Please ask for: Ms Iqraa Malik
Email: iqraa.malik@terraquest.co.uk
Telephone: 01212341390
Our Ref: FG/110/21/HH
Your Ref:
Date: 22nd June 2021

Application for Planning Permission for Works or Extension to a Dwelling

Development: Erection of single storey rear extension following the demolition of existing rear conservatory
Location: 64 Langbury Lane Ferring BN12 6QA

1:500 scale print at A4, Centre: 509119 E, 103232 N

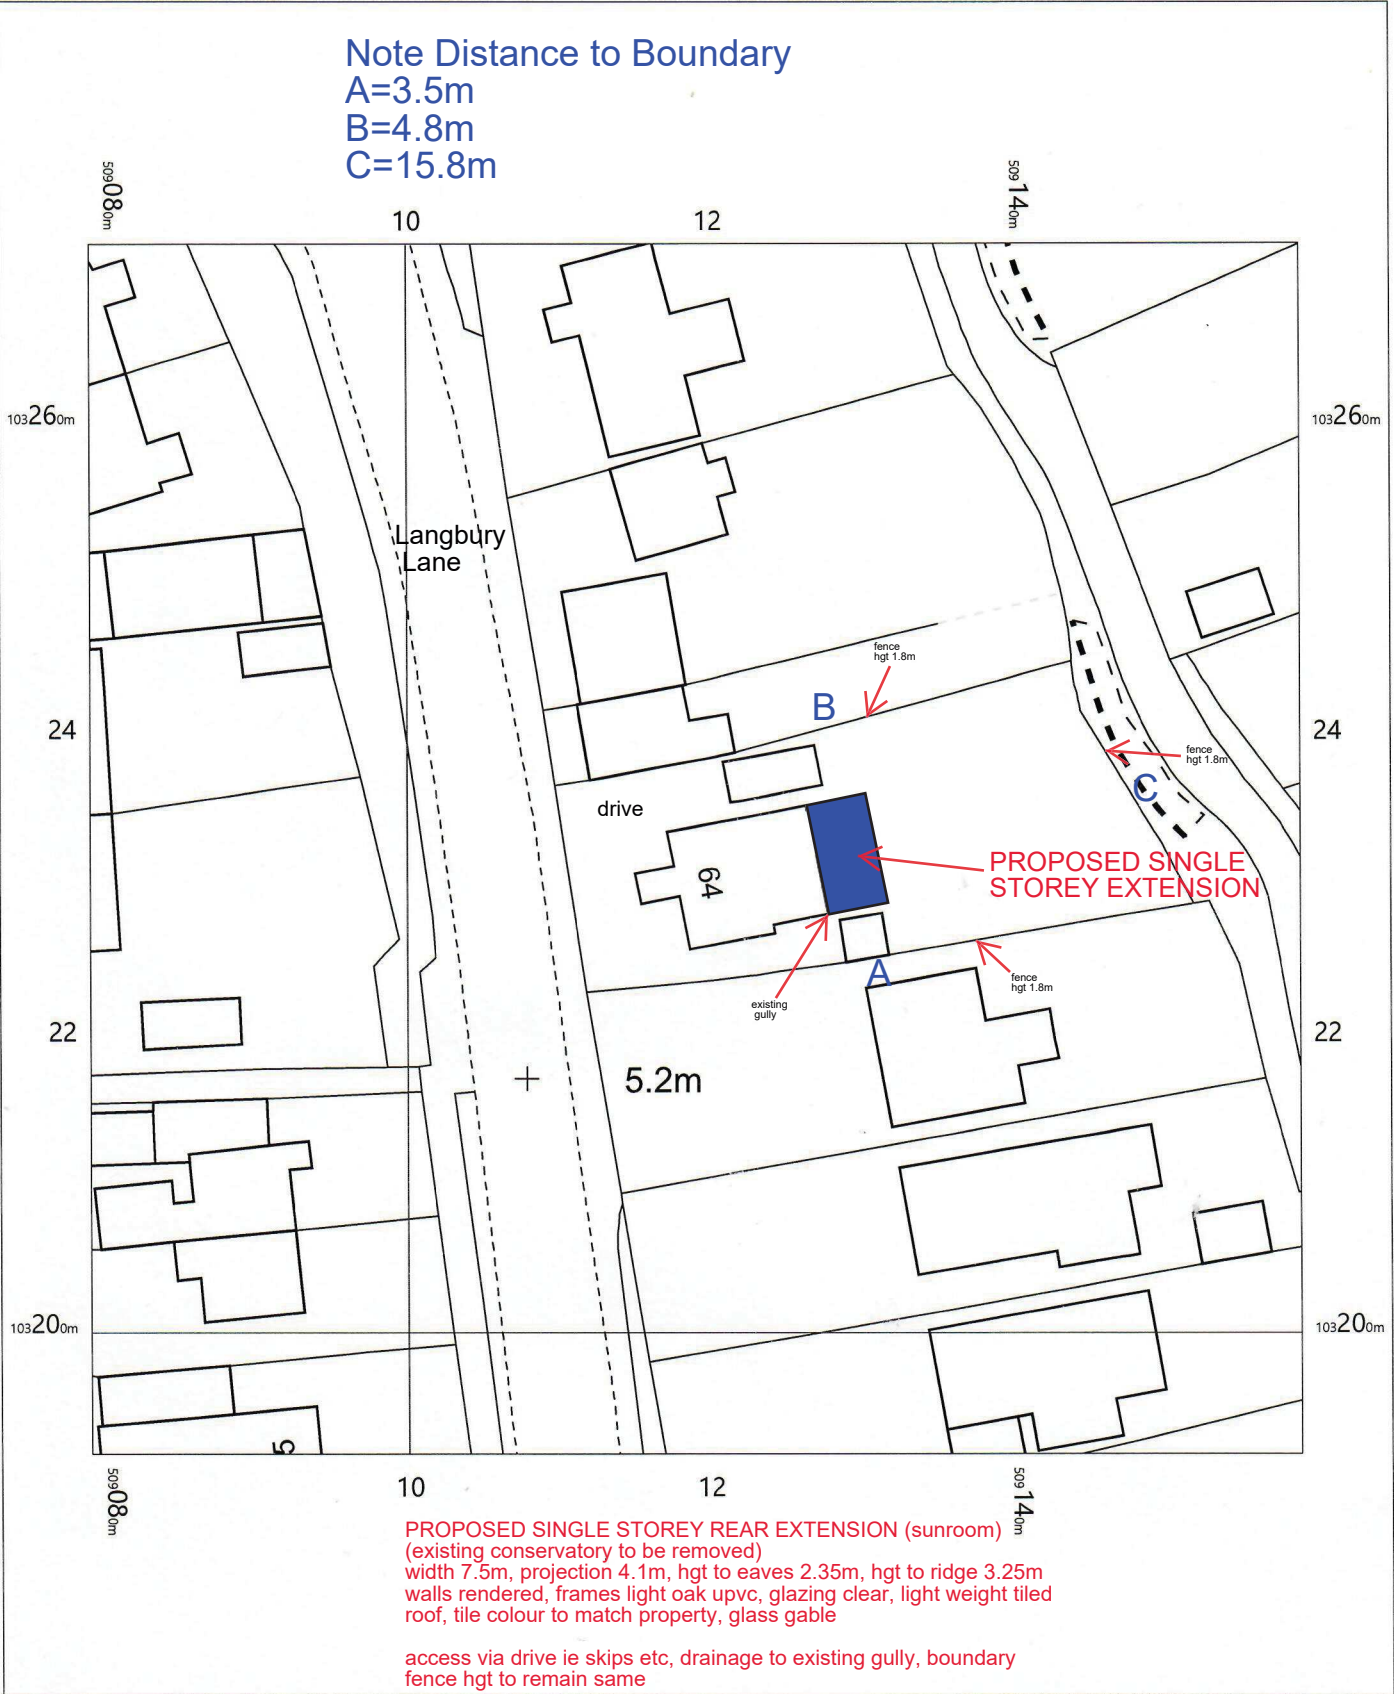
Location Plan

Please add a scale bar to the location plan

GROUND FLOOR LAYOUT

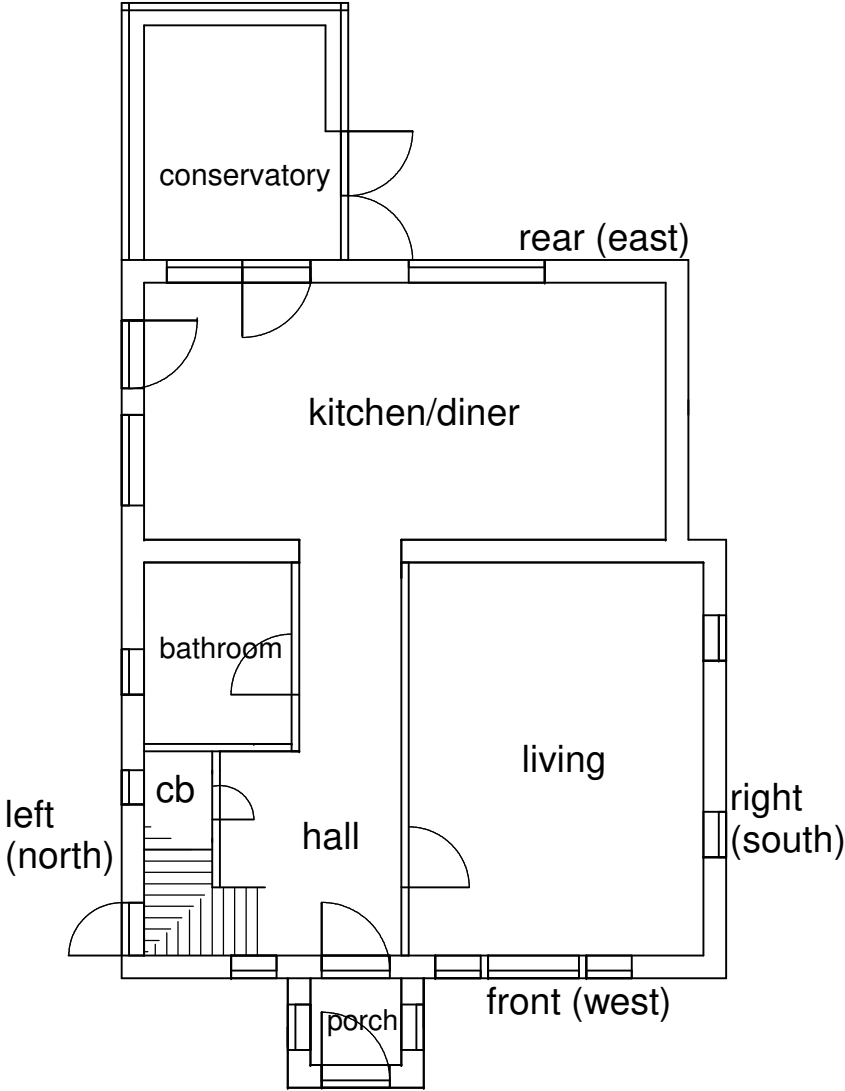
Floor Plans

Please submit clearly labelled existing and proposed ground floor plans at a scale of 1:50 or 1:100. Further details can be found in the Validation Requirements List.
